September 21, 2023

Project: Madrona Crest Lot 9, 3605 86th Ave SE, Permit # 2306-185

I have reviewed the SDCI review correction notice and have the following responses to the Structural items. Please note that the numbers of my responses correspond to the numbers on the correction sheet.

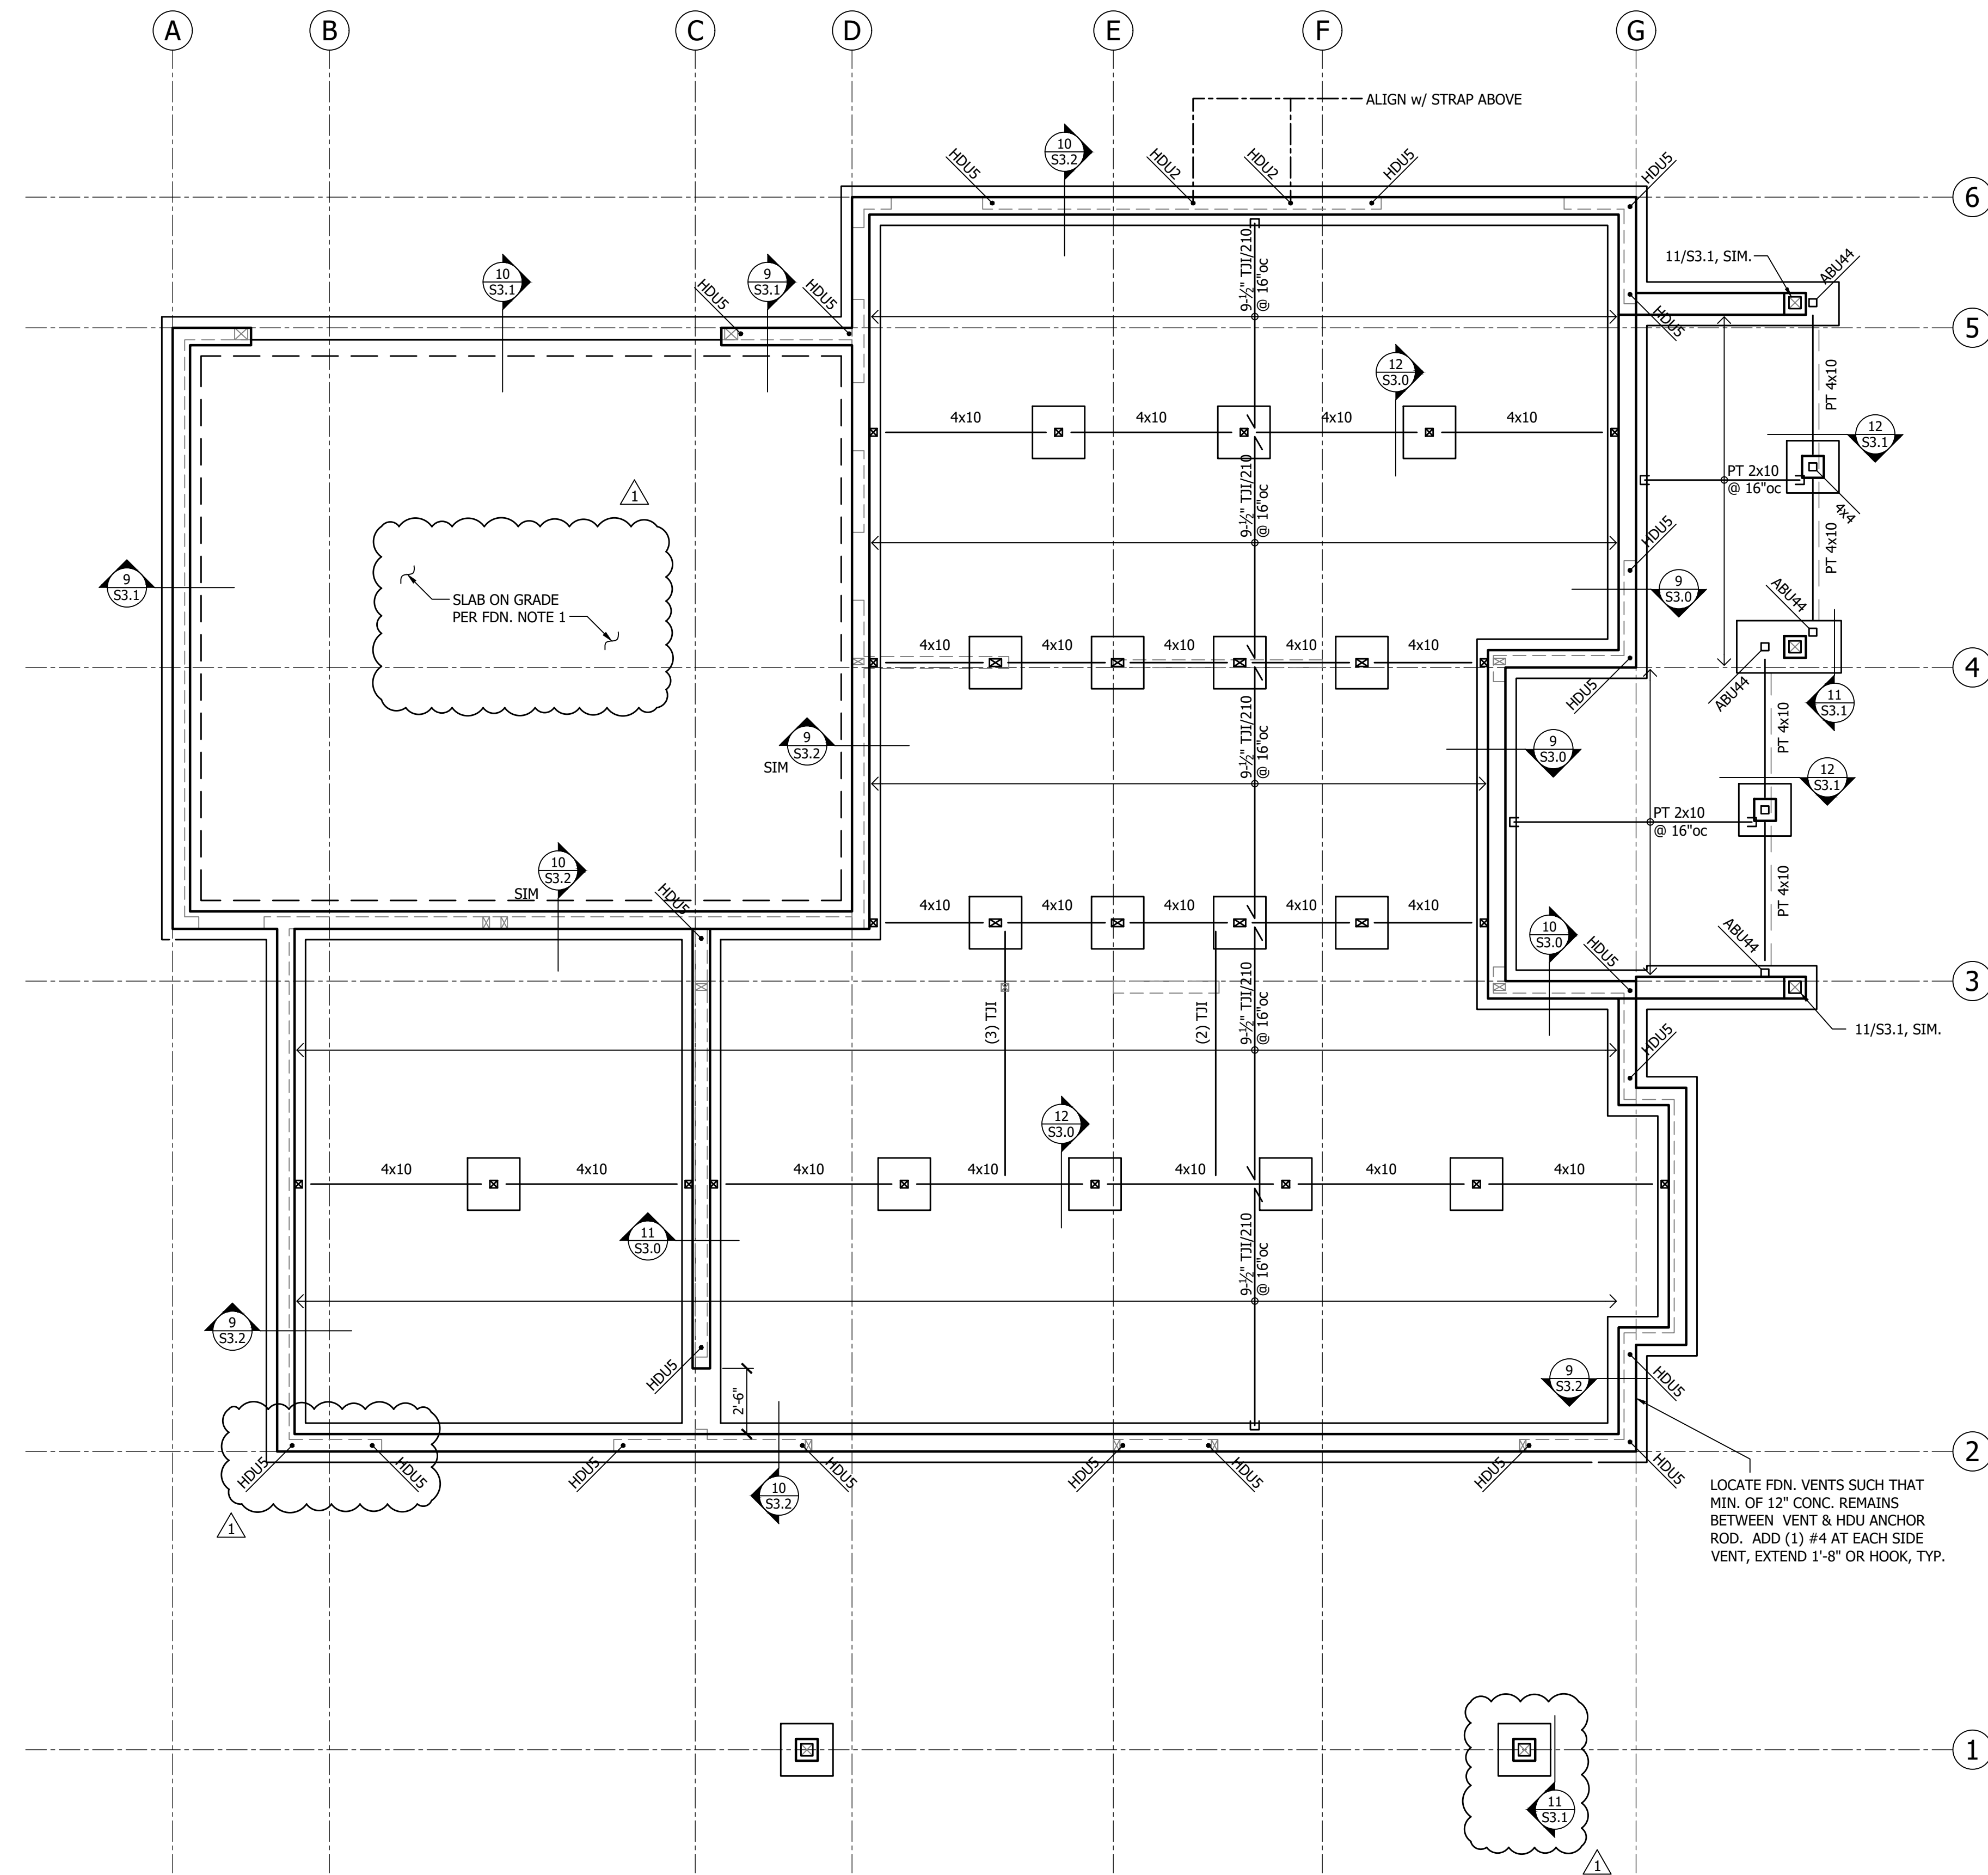
8. Detail 1/S3.0 is cut on Sheet S2.0 in the middle of the garage. Please clarify intent.

11. Detail 1/S3.0 is cut at the isolated footing at the south patio along Grid 1 on Sheet S2.0. Is detail 11/S3.1 really intended?

18. It appears that holdowns are missing from both ends of the 4' long shear wall along Grid 2 at the south wall of the Family Room, Sheet S2.0. See page 6 of the calculations.

Response: Cut and paste error, this reference has been removed from sheet S2.0.

Response: Sheet S2.0 has been revised to show detail 11/S3.1 at that location.

Response: These holdowns have been added to the plan, see Sheet S2.0.

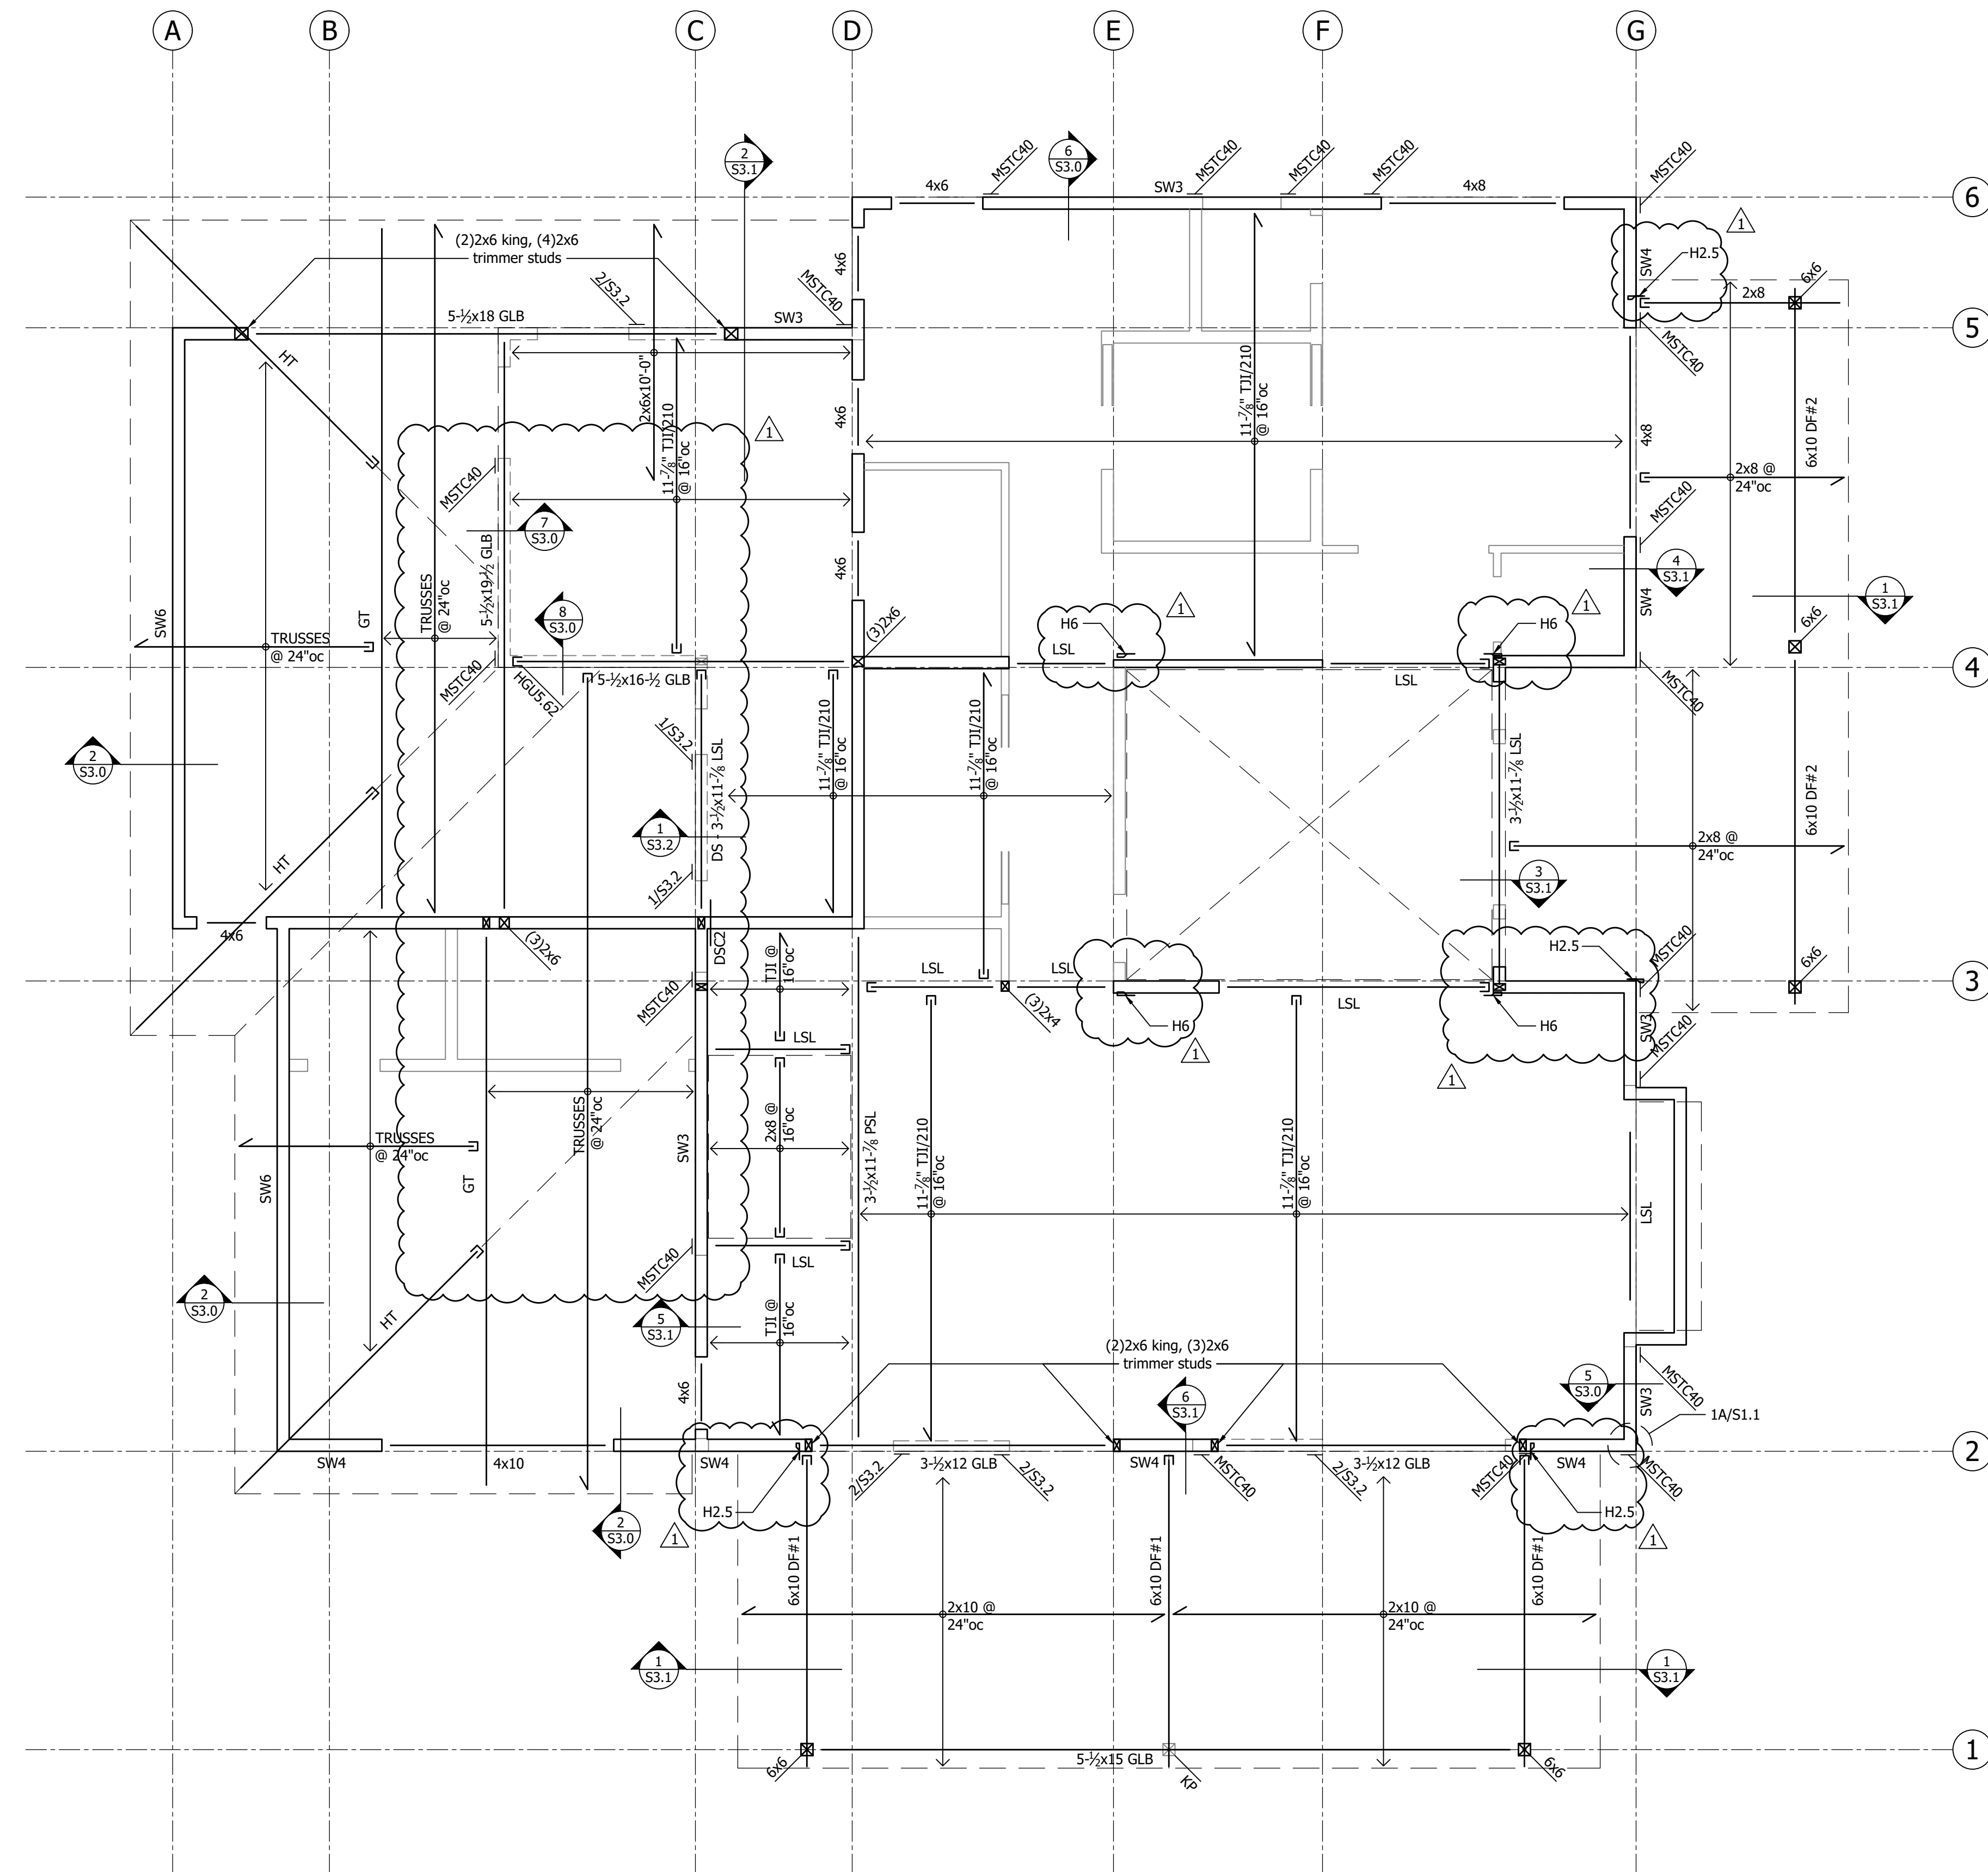
6. Detail 1/S3.1 is cut at porch roofs on Sheet S2.1. Verify uplift connection capacity.

10. Sheet S2.1 calls out typical LSLs which are 1-3/4 x 11-7/8 LSLs. Beam 8, identified on page 8 of the calculations, is designed as a 3-1/2 x 11-7/8 LSL per page 14 of the calculations. Please revise the callout on the Upper Floor Framing Plan.

19. Please verify that the CS16 holdown straps have sufficient capacity for the shear walls along Grids B/C on the Upper Floor Framing Plan, Sheet S2.1. Where strapping to an LSL, it appears these straps would not have a sufficient end length to get the full capacity. At this location, Detail 1/S3.2 is cut which shows an MSTC48B3 strap instead of a CS16 strap. Please resolve discrepancy.

21. Per ASCE 12.10.2, collector elements must be provided that are capable of transferring the seismic forces originating in other portions of the structure to the element providing the resistance to those forces. It appears that a drag member and connector may need to be provided along Grid C on the Upper Floor Framing Plan, Sheet S2.1. Please verify.

22. How are lateral loads resolved at porch roofs?

24. Floor framing notes on Sheets S2.0 & S2.1 call for 3/4" sheathing with 0.113 nails at 6" on center at panel edges and 12" on center at intermediate framing. Will these nails be sufficient for diaphragm shears?

Response: See the attached calculations. The designed connection is within 6% of allowable steel stresses so it is acceptable in my professional opinion.

Response: This beam call-out has been revised on Sheet S2.1 to match the required beam in the calculations.

Response: The straps along this lateral line have been revised to MSTC40 for walls and deep beams, or to 1/S3.2 at the 11-7/8" LSL beam, see revised Sheet S2.1.

Response: Beam #8 along grid C on the Upper Floor Framing (ref. S2.1) has been denoted as a Drag Strut ('DS') per Floor Framing Note #4 on Sheet S2.1 and a DSC2 connector has been indicated on the plans to transfer the load to the shear walls farther along that lateral line.

Response: See the attached calculations for the required force to resist rotation the low porch diaphragms. Connector notes have been added at each low roof porch framing, see S2.1.

Response: The maximum diaphragm shear is 73.2 plf < 140 plf (SDPWS, Table 4.2C. 6d nails, Case 4) therefore the 0.113" nails at 6" and 12" are adequate.
